**Consultation Response from KC,
Conservation & Design****2024/91820 The Message, 2-4, Crescent Road, Birkby, Huddersfield, HD2 2TF****Erection of lean-to single story front extension (within a Conservation Area)****Date Responded: 08.08.2024****Responding Officer: S Pickles****Responding Ref:**

PROPOSED PLANS.

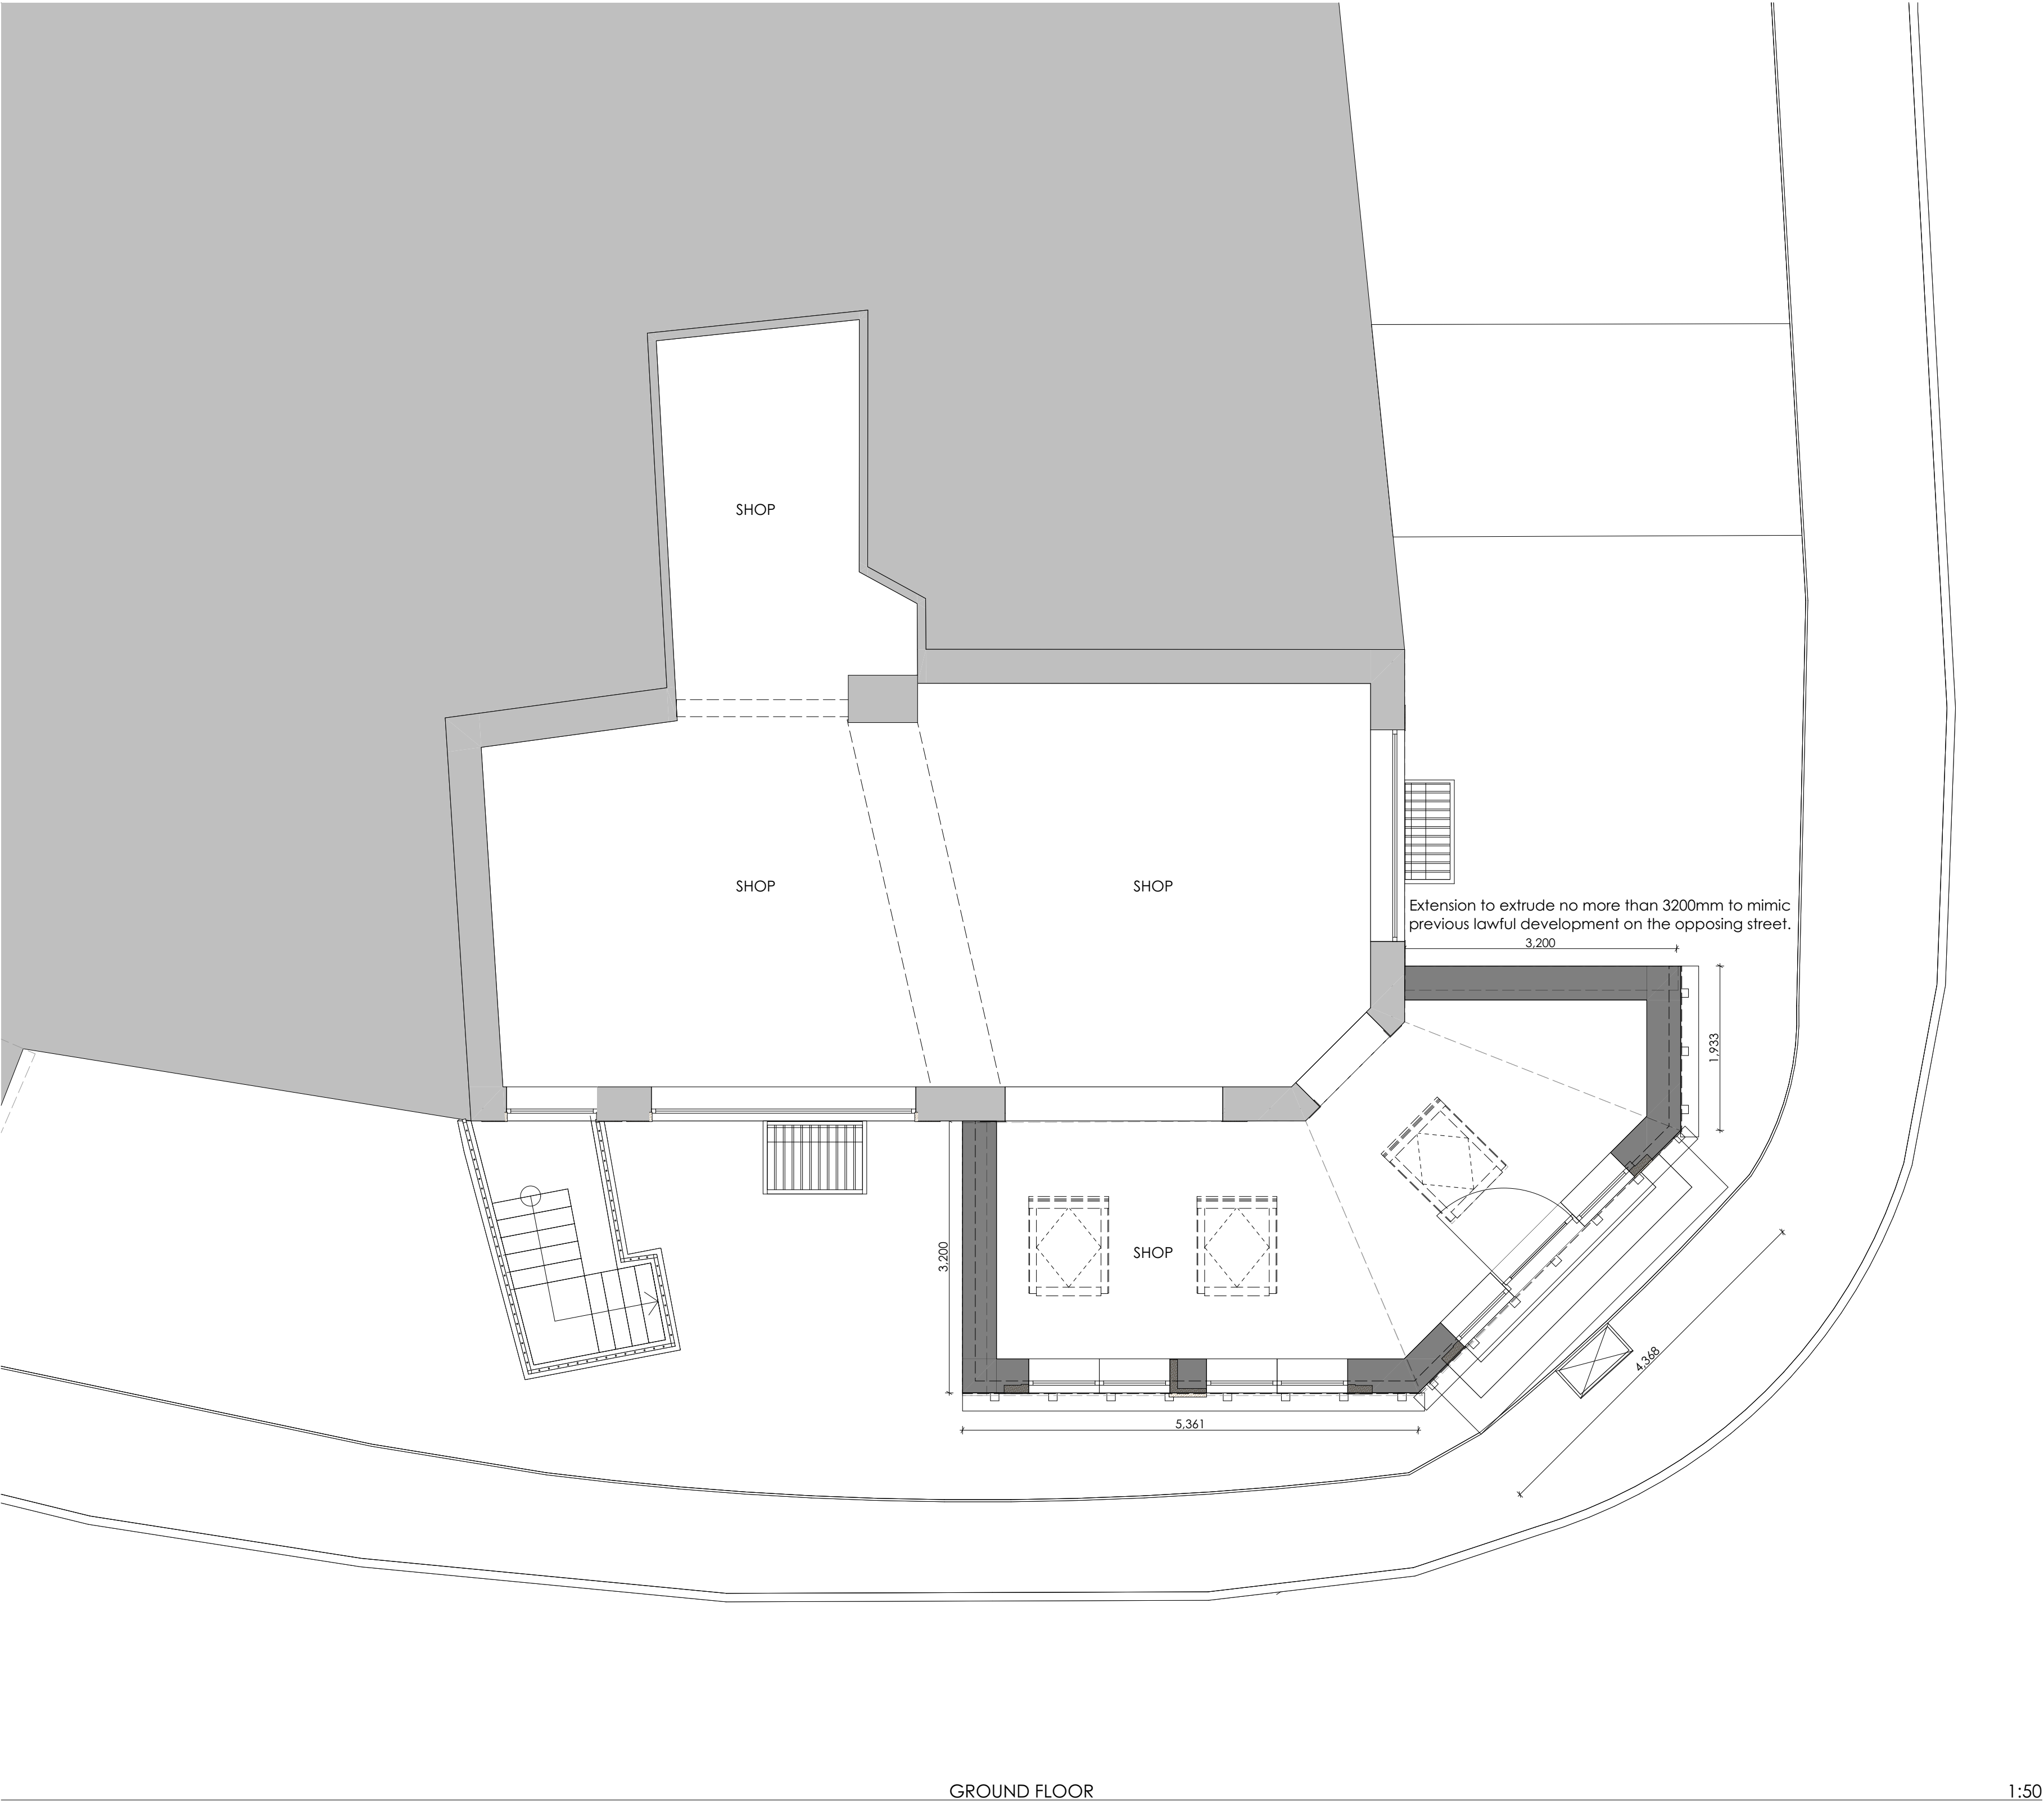
The proposed extension would wrap from the front left-hand side, cover the side entrance door, and extends round to the right-hand side.

While we recognise that consideration has been given to the proposed material palette, we are not convinced by the proposed extension. The extension, while making reference to architectural details and making use of an appropriate material palette does have a feel of a more domestic extension, something akin to what would be found at the rear of a dwelling.

The example noted of the former canopy to the commercial market has a marked difference in that the former canopy was open, except those hours where the shutters were down. We note that there was a further application to apply glazing to the front of the canopy, however again, this was more of a lightly weight structure which had the feel of a natural extension to the building. The proposed extension, while having some positive detailing, does feel heavy in form and does not reflect the character of the host building. If a modest open or glazed/ partially glazed canopy was being proposed, then this is something which could be given further consideration to. We are however not convinced that the proposed extension forms a natural extension to the building.

As proposed, we are not convinced that the extension meets the test of LP24 or LP35 of the Local Plan. If the proposal was made to be more of a canopy-style extension, more lightweight and less obtrusive then we may be able to support the proposal, subject to further assessment and consideration. As set out we are unconvinced by the current proposals.
